April 8, 2005

RE: Application for Single Family Residences, Ruby Lane lots #1, 2, and ~~17~~ ¹⁶

Upon review of the site plans, the City's Planning Division has the following comments:

LOT 17 LAYOUT & UTILITIES PLAN

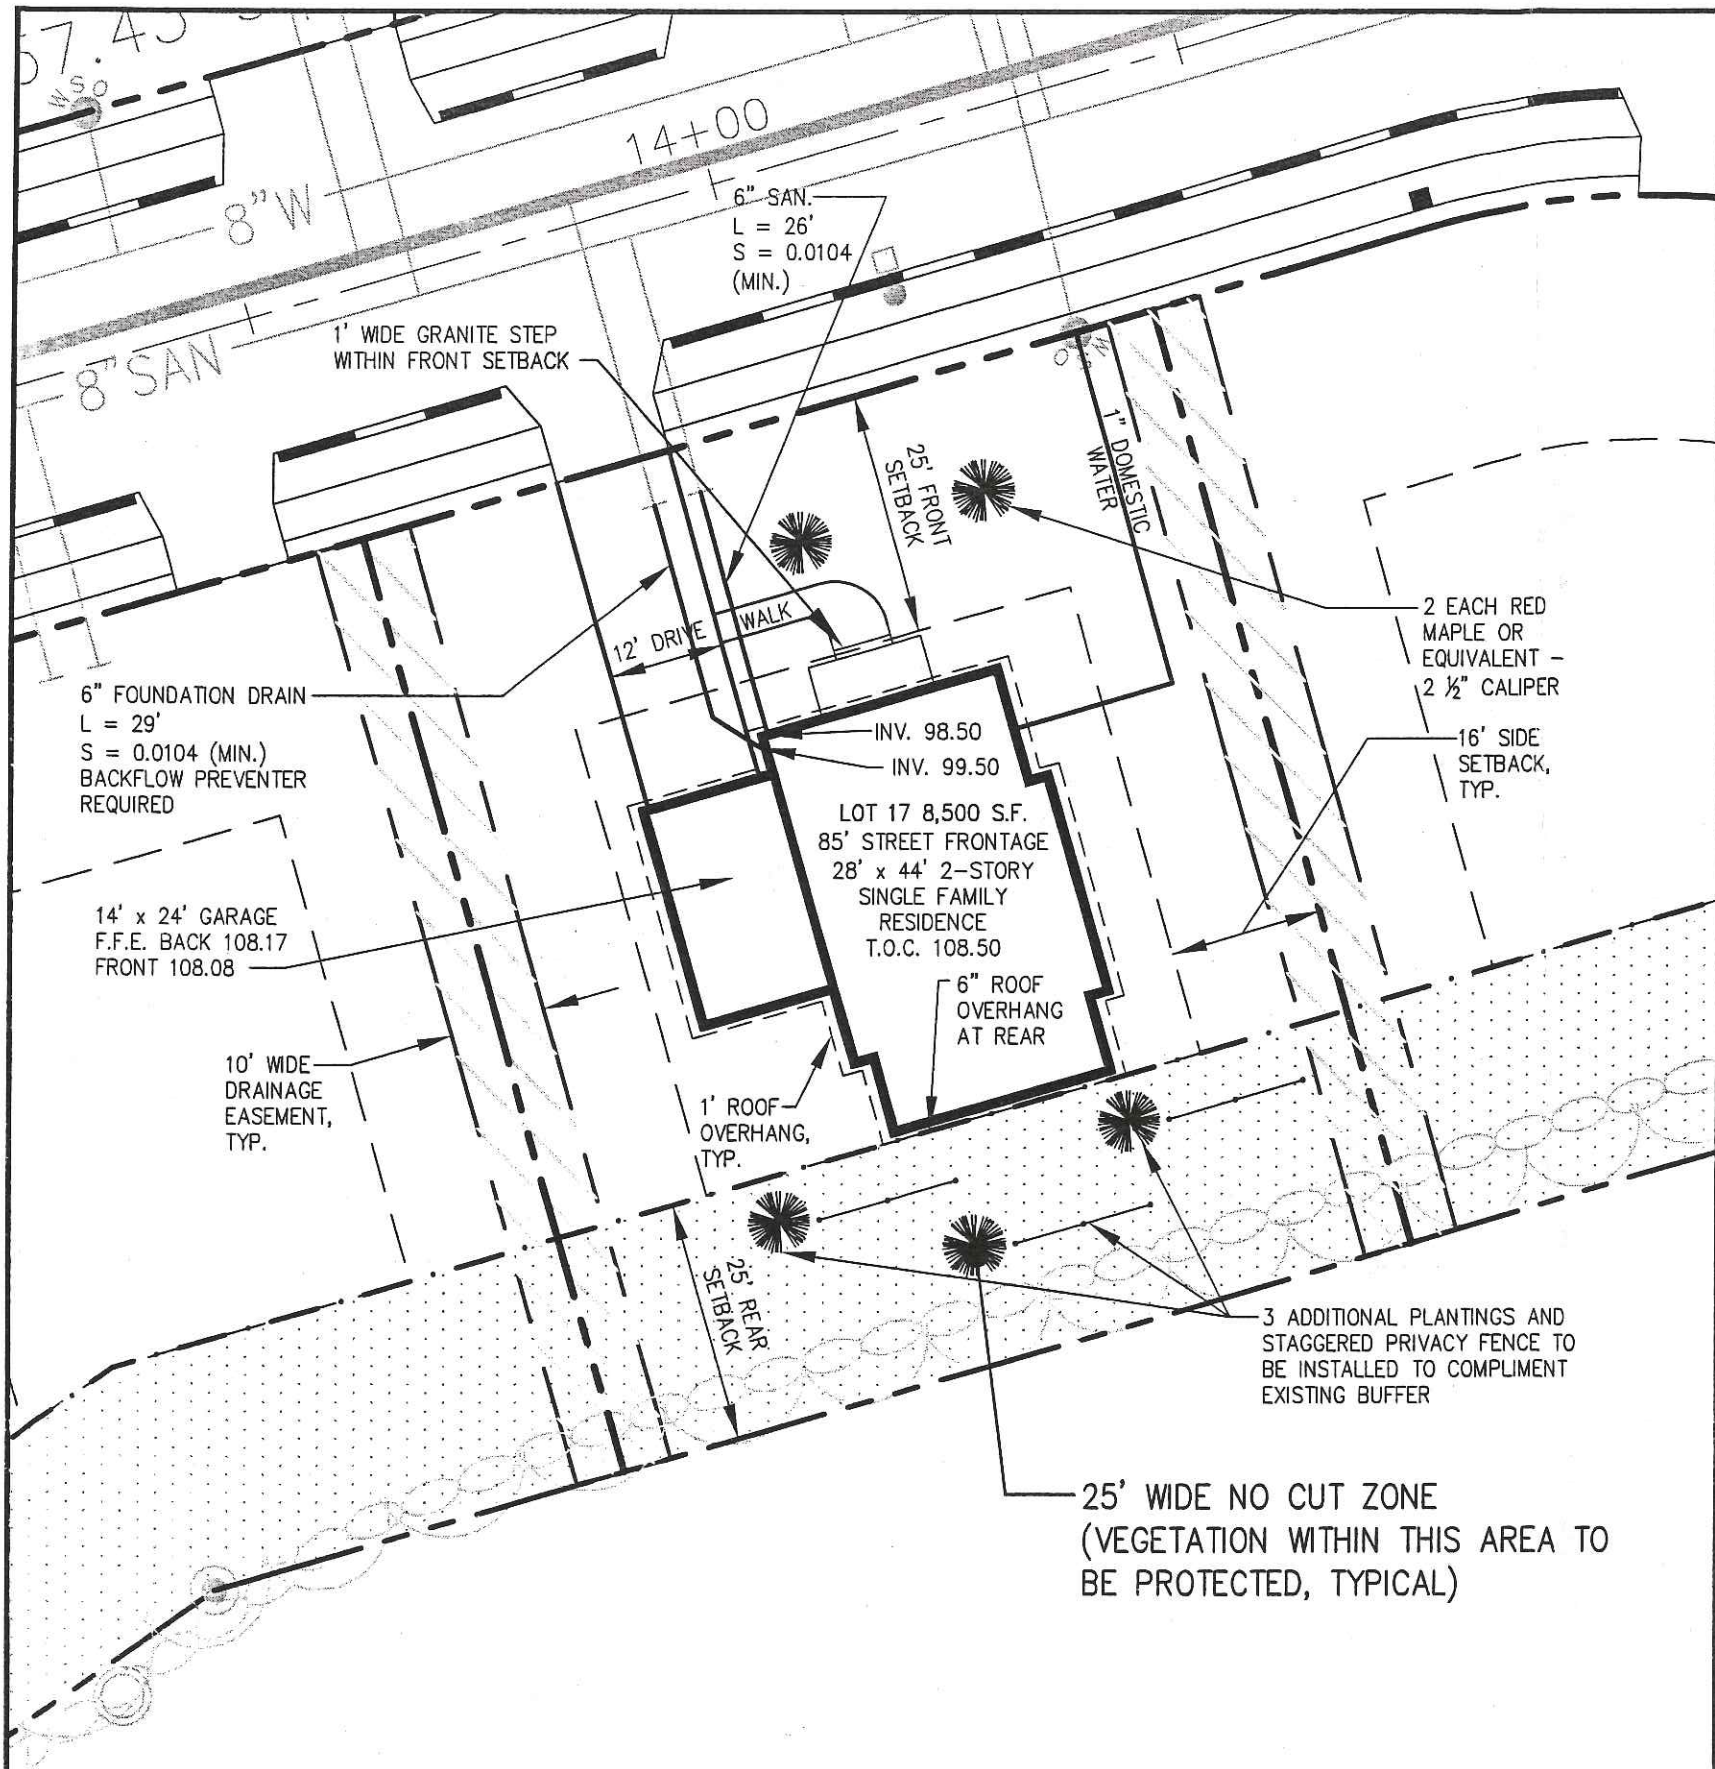
1. This application is not showing the required 2 parking spaces outside of the front setback. Please revise.
